Charlotte Department of Transportation

Memorandum

Subject: Rezoning Petition 04-136: East of the intersection of Moores Chapel Road and Belmeade Road (Revised 2/18/05)

**ILLUSTR.
SITE /
LANDSCAPE
PLAN**

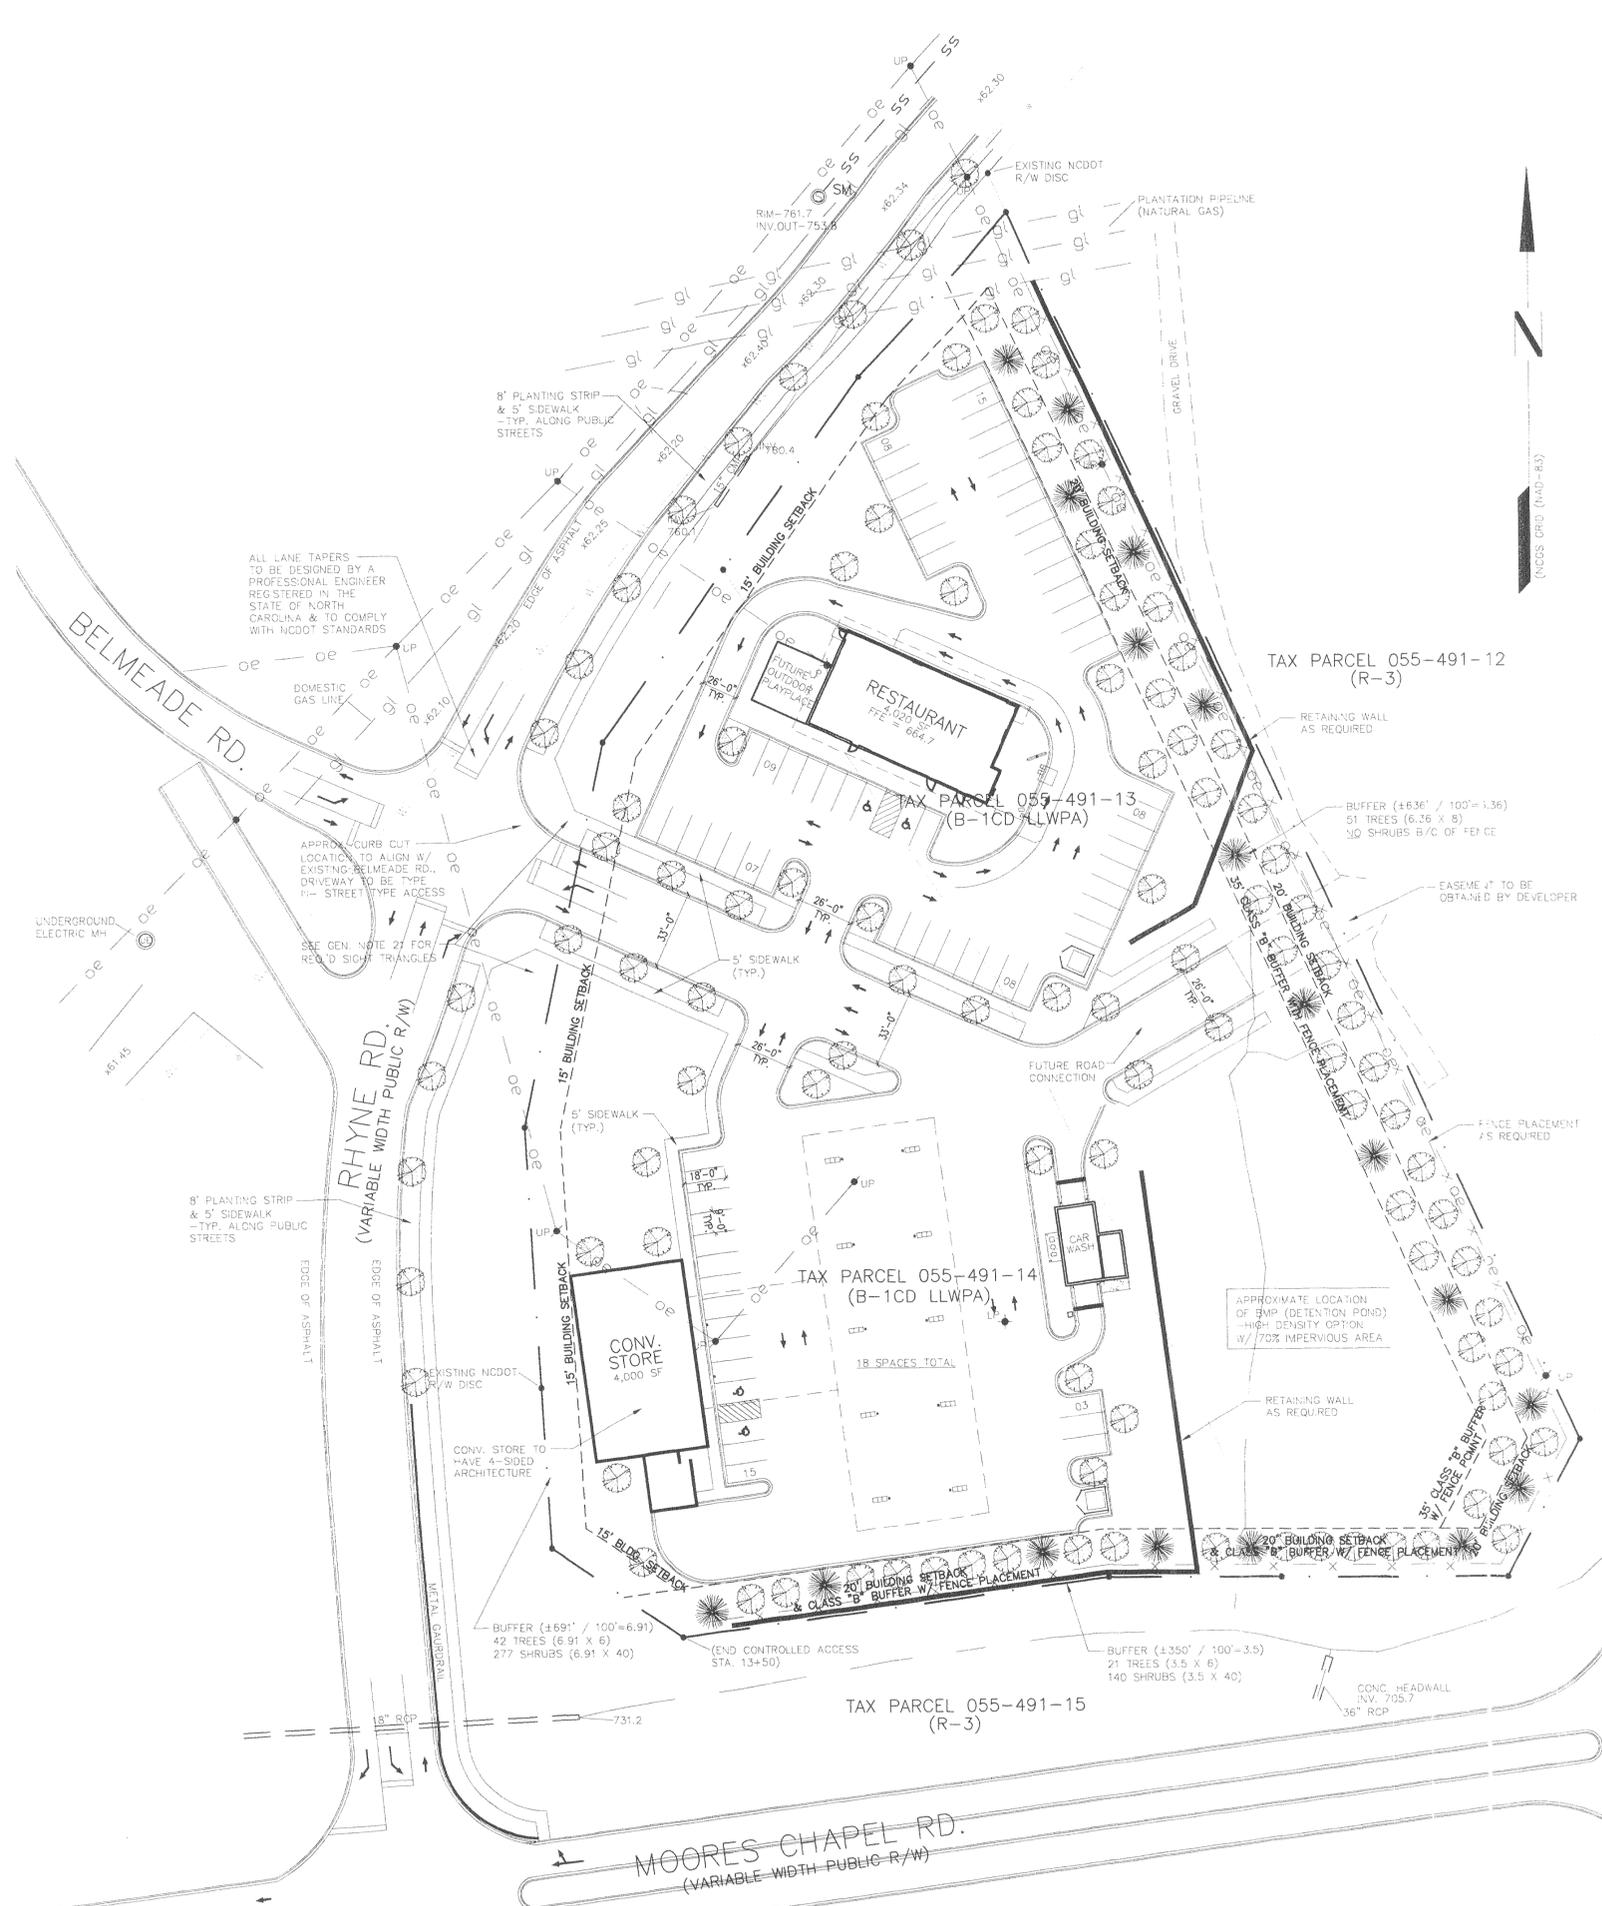
1. The site plan should reflect the TIS recommended developer road improvements and required access improvements with their design requirements. Access improvements should be distinguished from the final configuration of Rhyne, Moores Chapel and Belmeade Roads at completion of the NCDOT project. Items such as pavement markings, edge-of-pavement and right-of-way lines on both sides of all roads shown should be clearly illustrated on the conditional plan.
